Our ref: Winterbourne Wind Farm (SSD-10471)

18 August 2025

Subject: Request for Additional Information

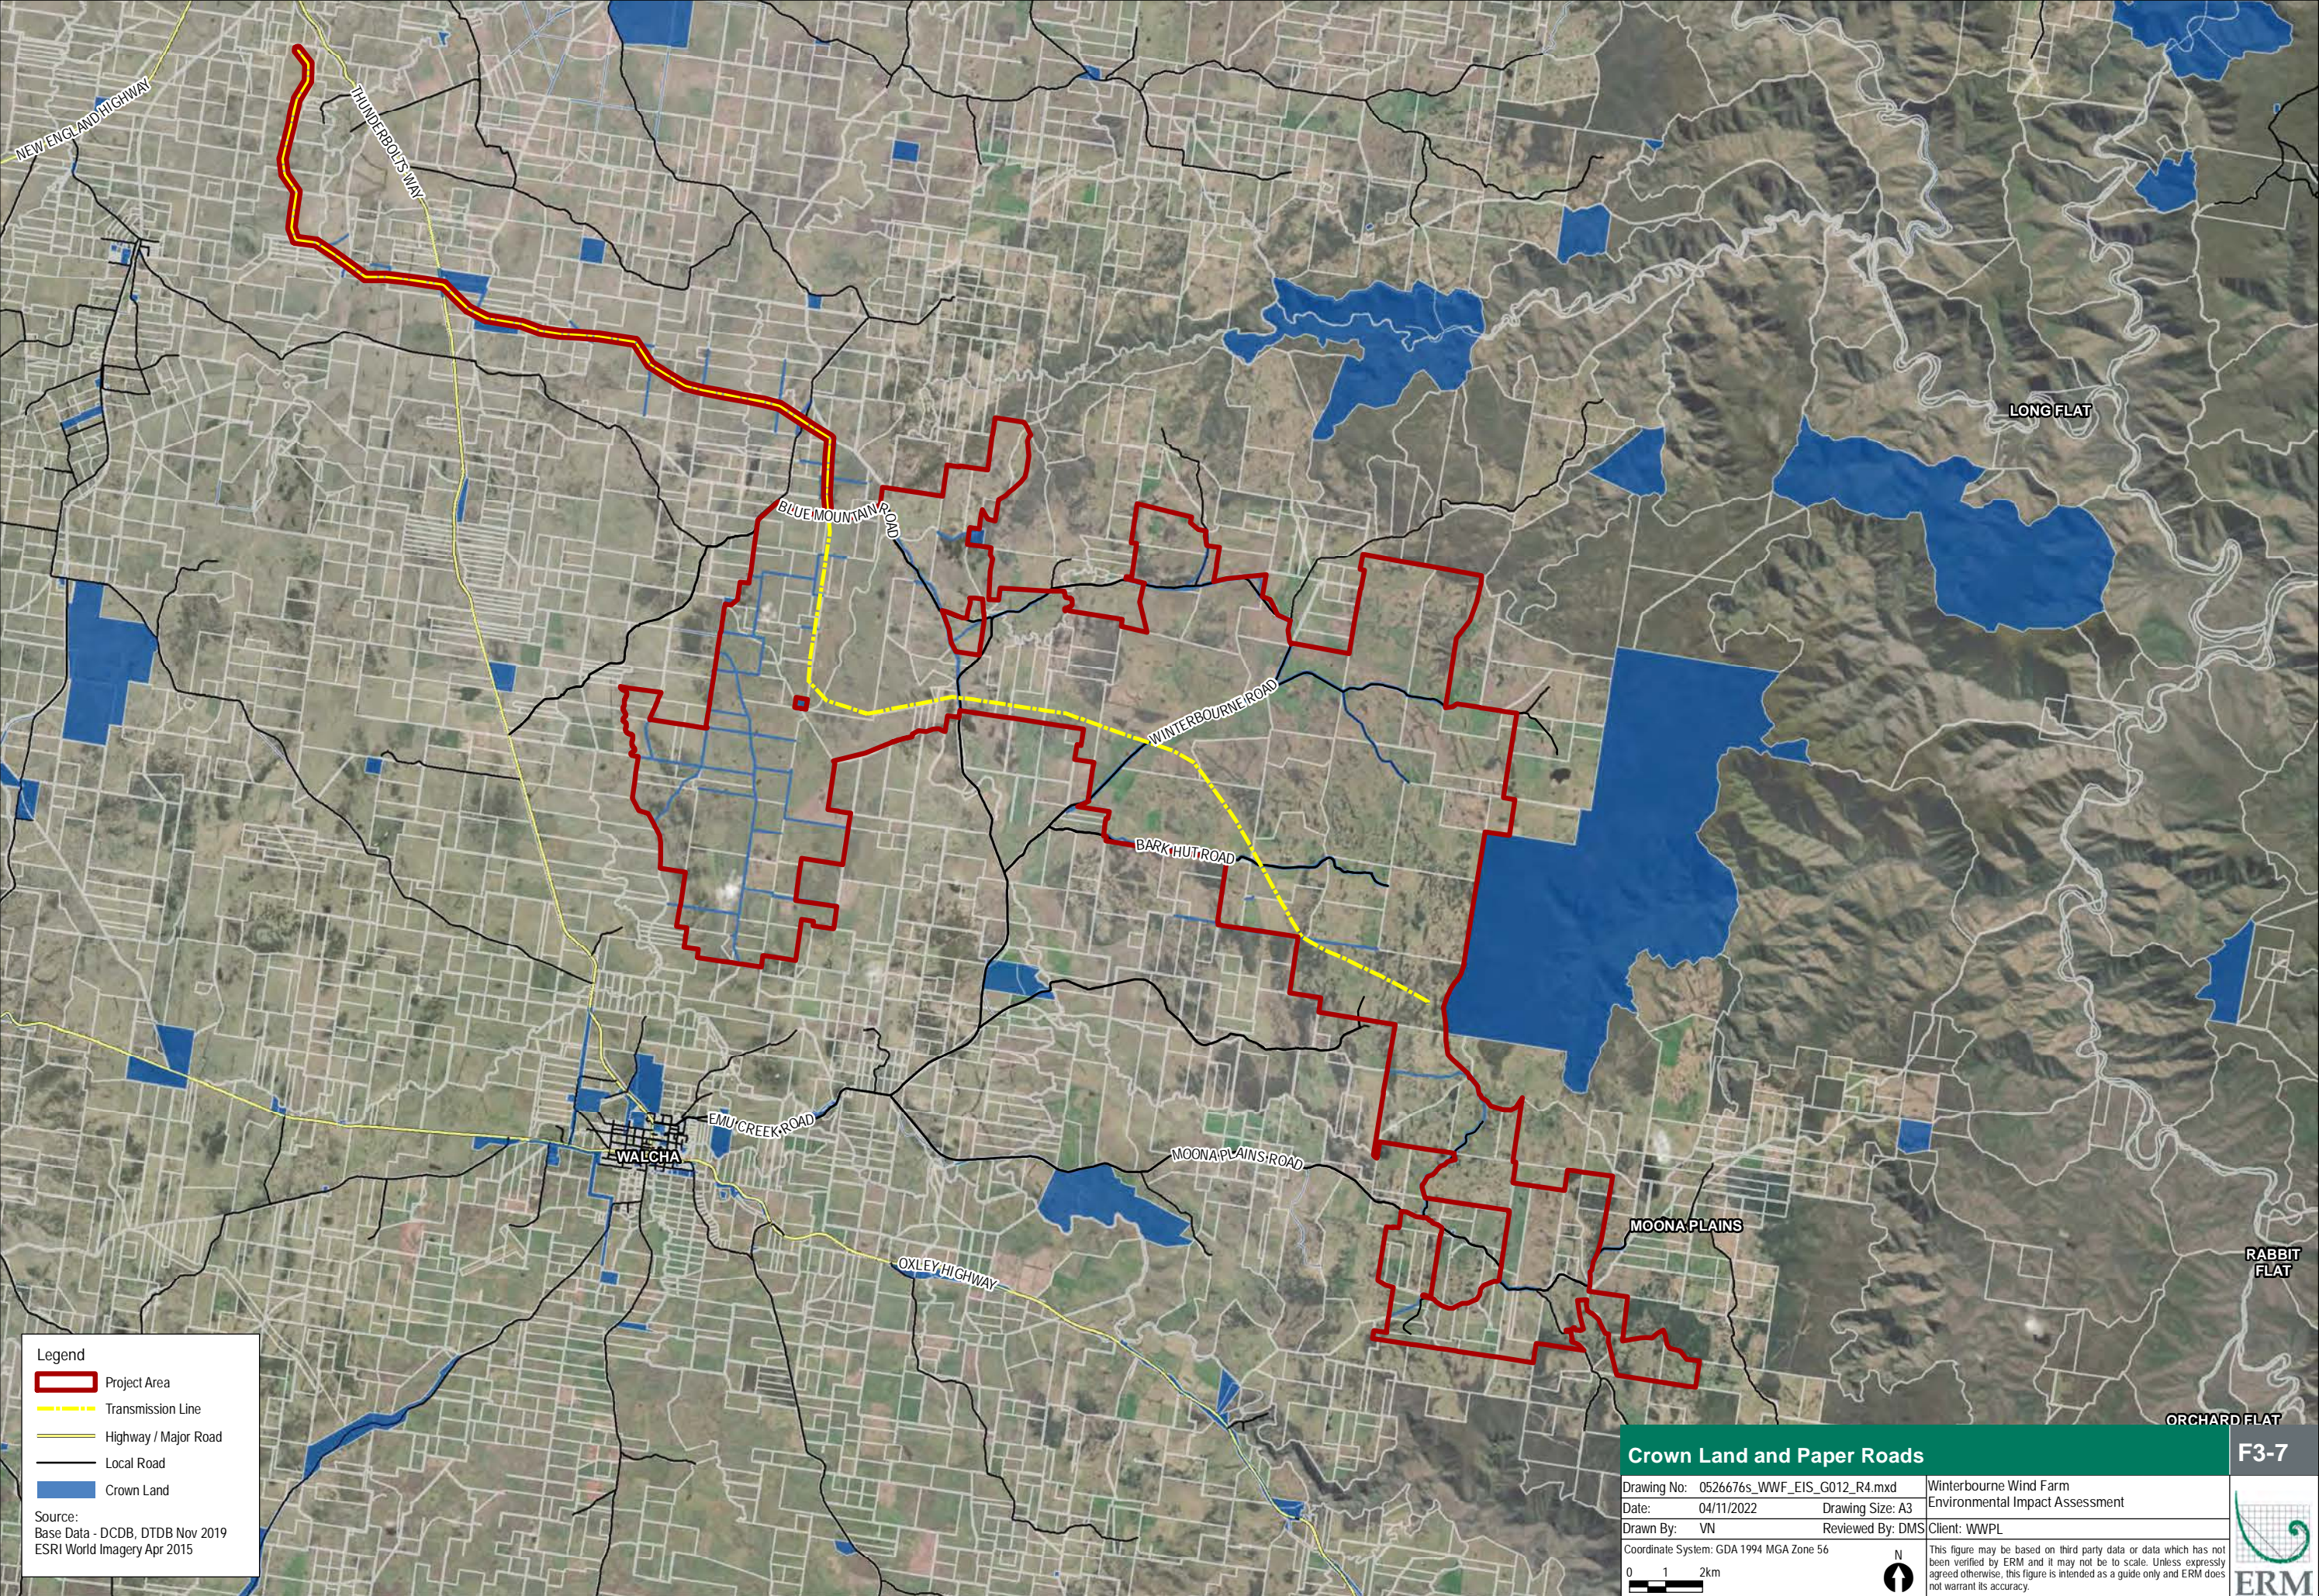
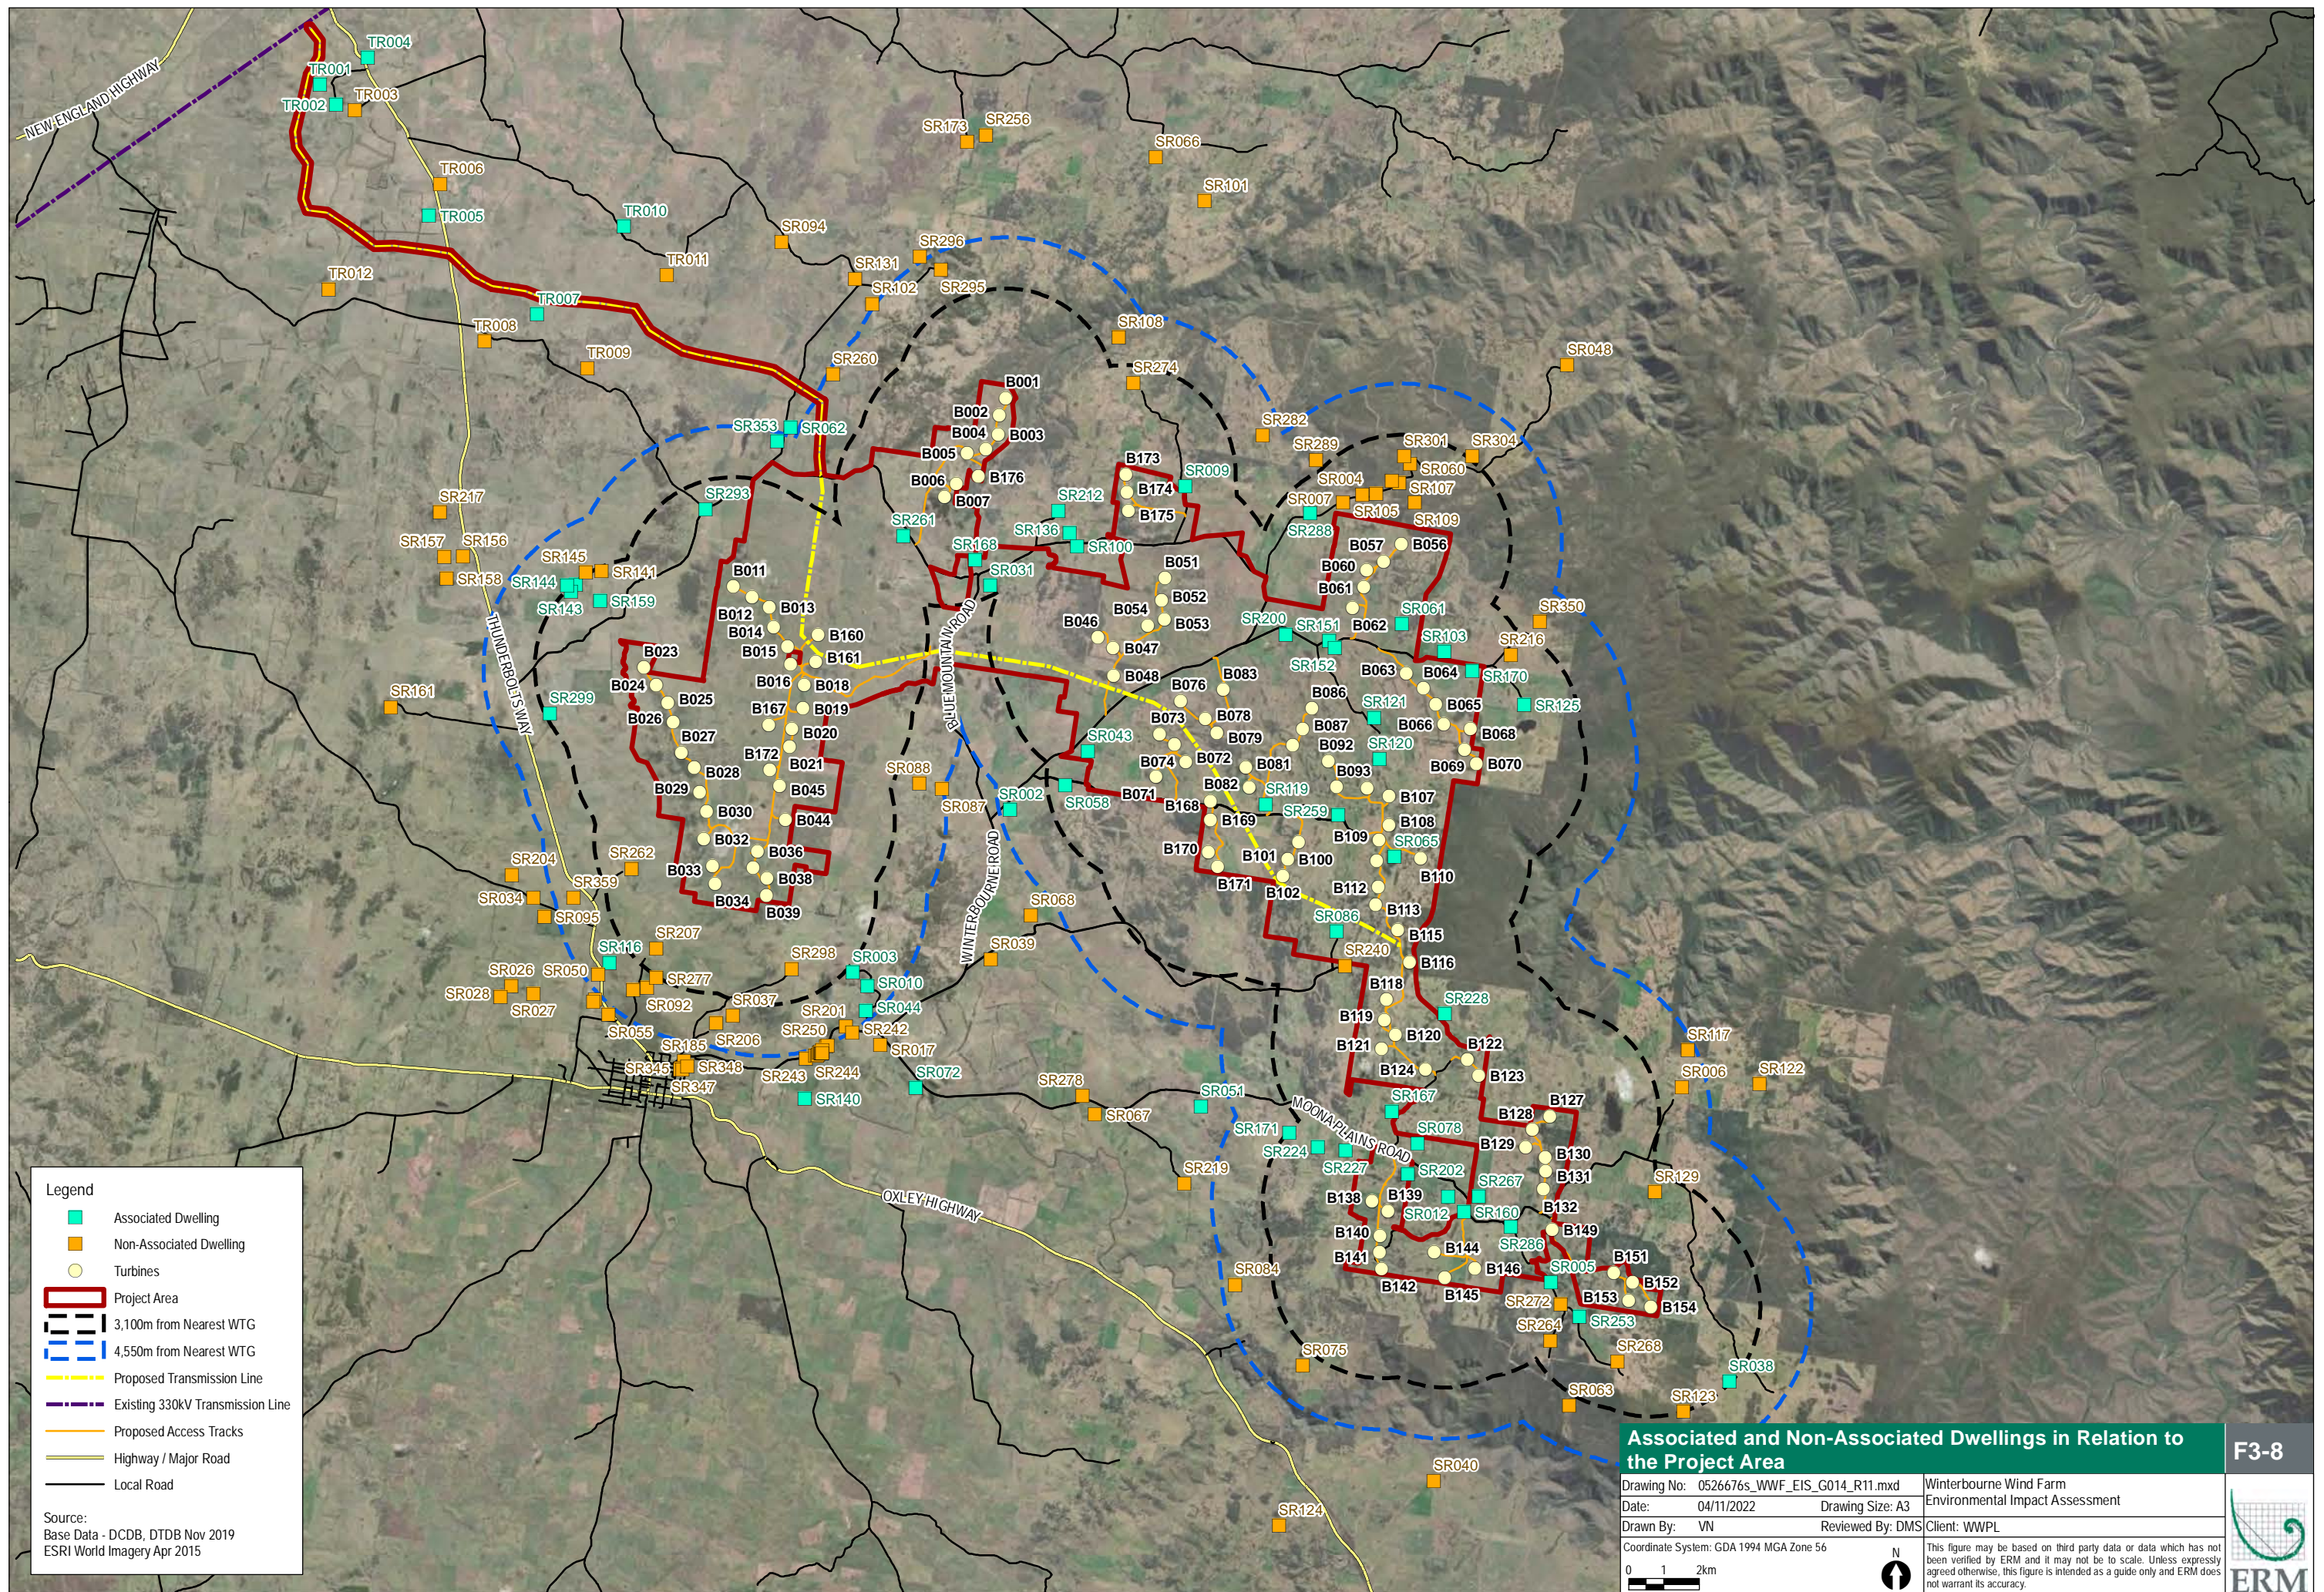
| Item | Comments |
|-----------------------|---|
| Traffic and Transport | <ul style="list-style-type: none"> Provide details of all proposed road and/or intersection upgrade works. Provide landowners consent for all land parcels facilitating the proposed road upgrades. |
